Date: 10/30/2023

Re: **Framing Item**
Location: 620 Mt Pisgah Church Rd. (Broadway, NC)
JDS Project No.: RDU2310043
Date of Inspection: 10/20/23

The client requested an evaluation of the cantilevered joists supporting the deck and porch ceiling at the rear of the kitchen.

**BRAD CUMMINGS CONSTRUCTION**  
**KEANE RESIDENCE**  
 FIRST FLOOR EWP PLACEMENT PLAN  
 Builders FirstSource, Central Carolina Markets  
 DRAWN BY: MARK BROOKS DATE: 1/11/2023  
 SCALE: 1/4" = 1' JOB NUMBER: 3303534

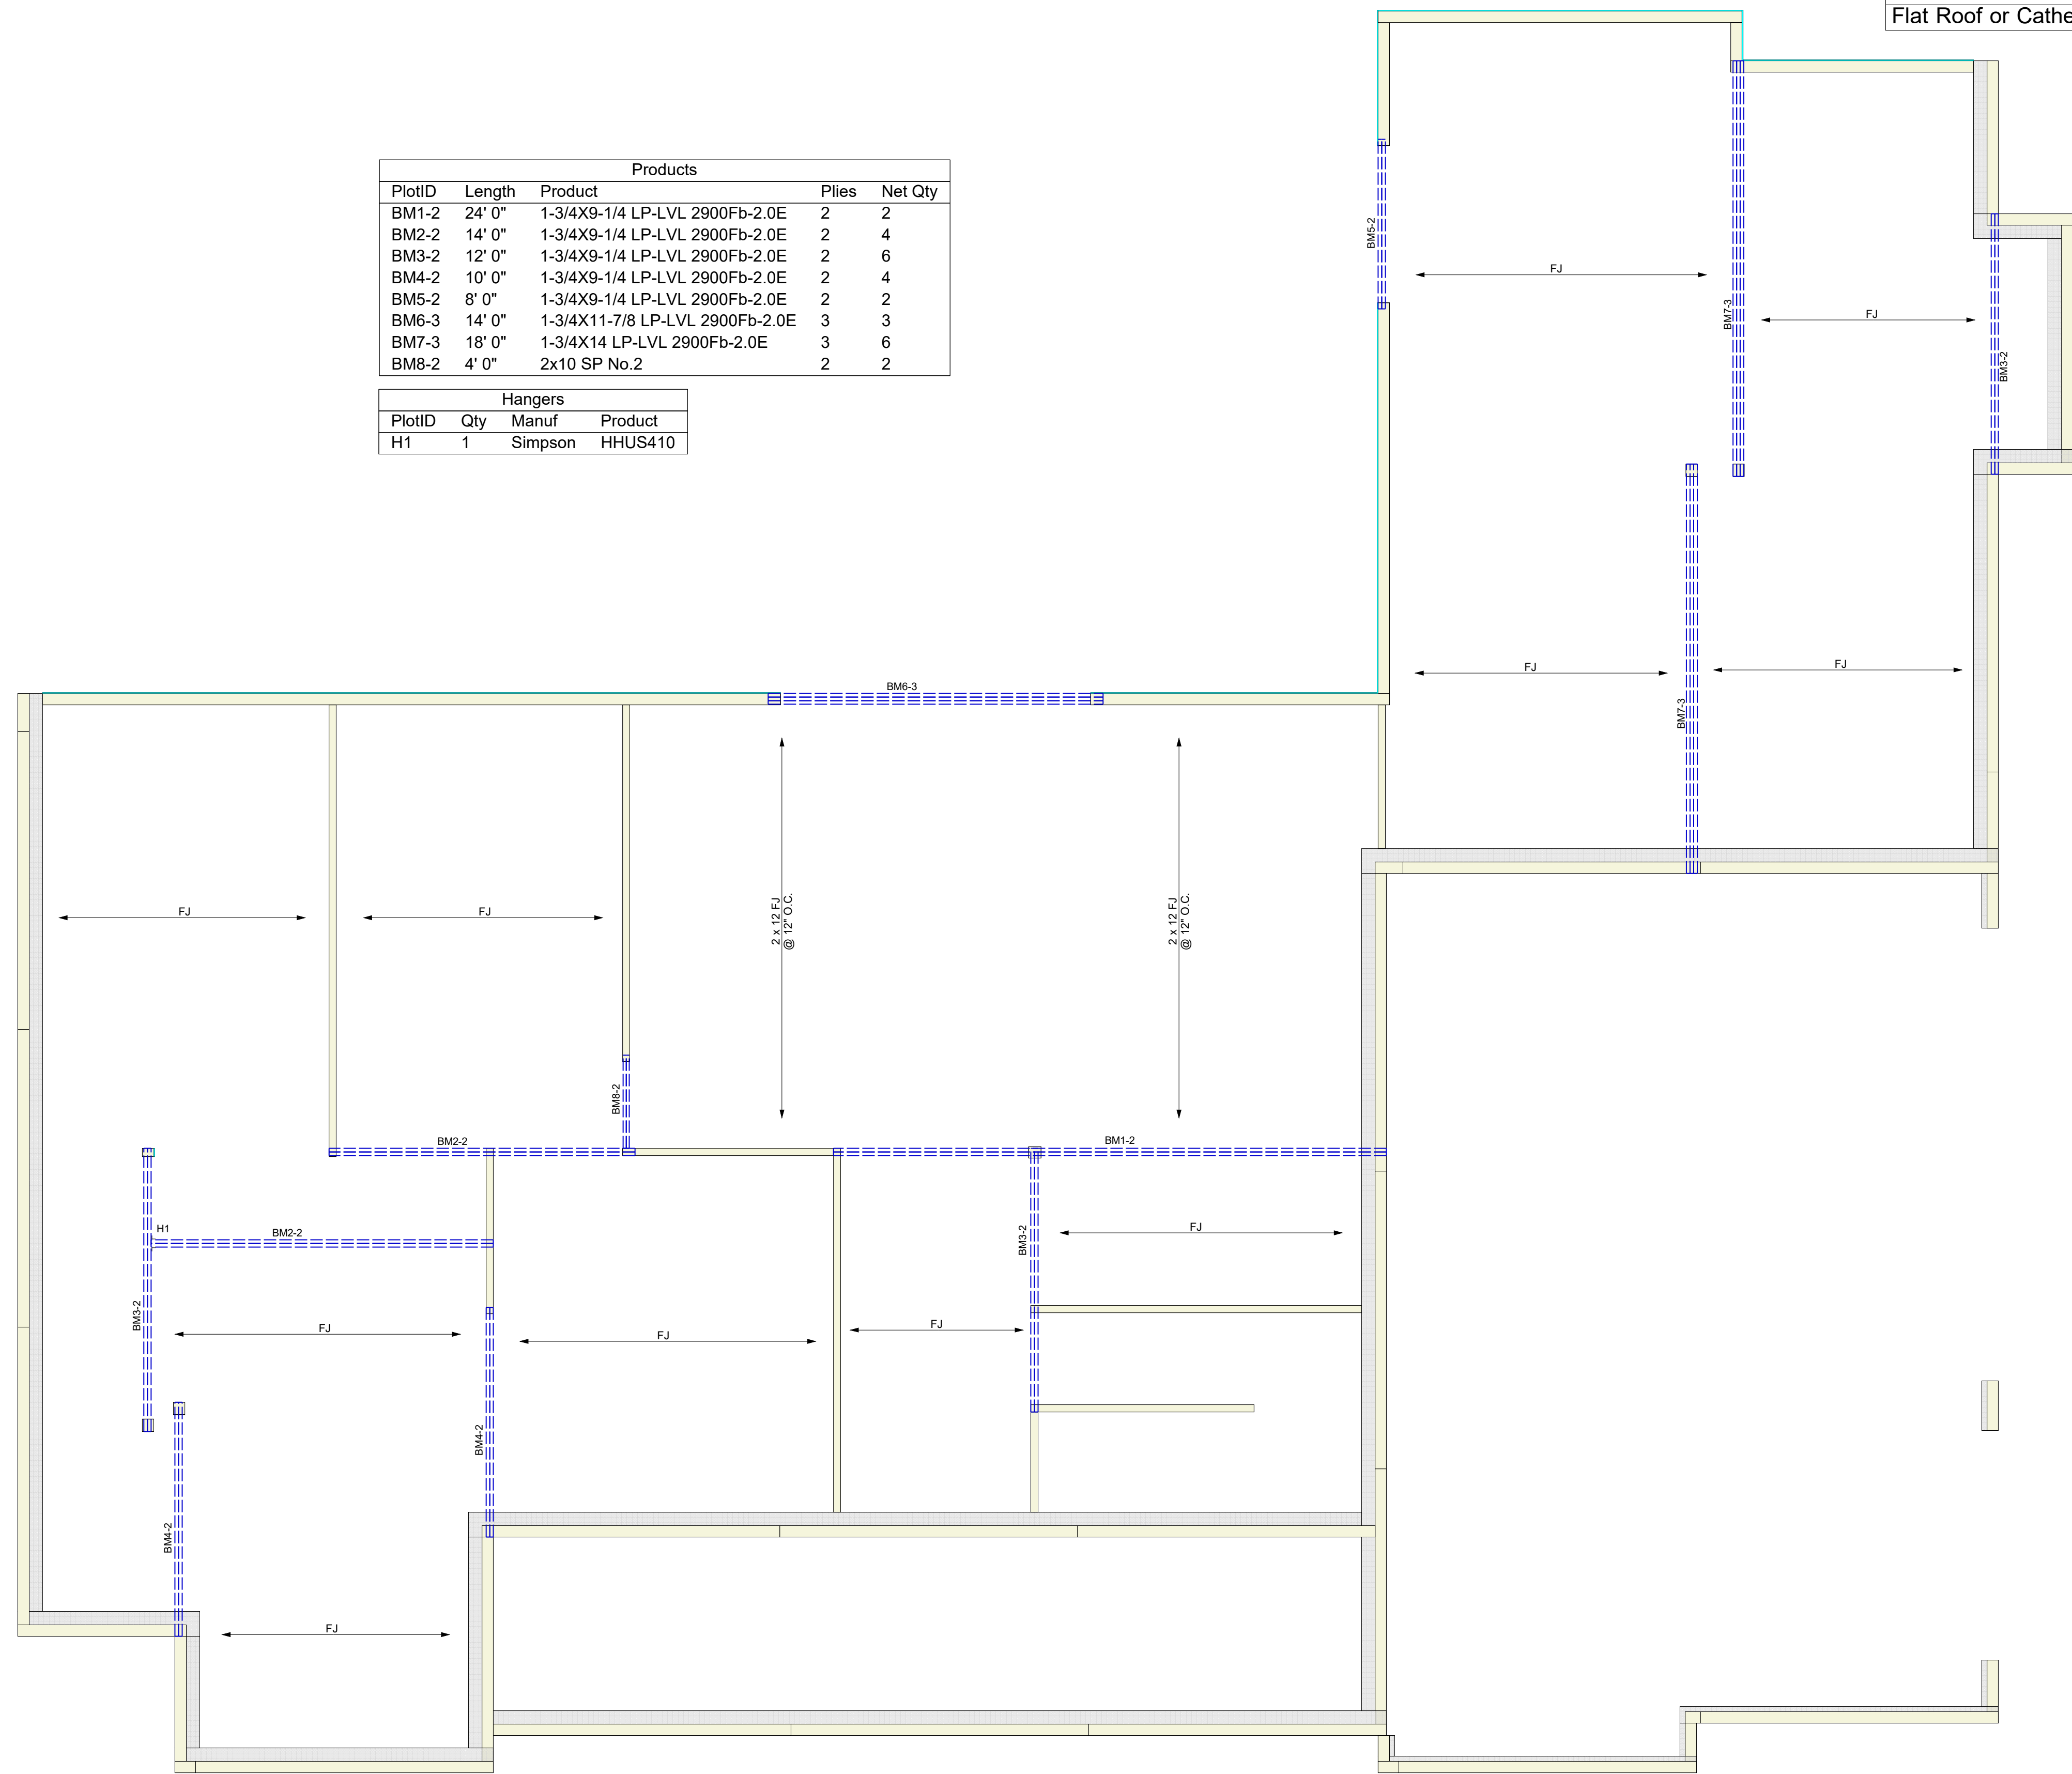
Based on our observations and review, the 2x12 joists should be doubled. Additionally, the rear band at the cantilever should be attached to the joists with a Simpson L90 on each side of the double joists and one Simpson L90 in each corner.
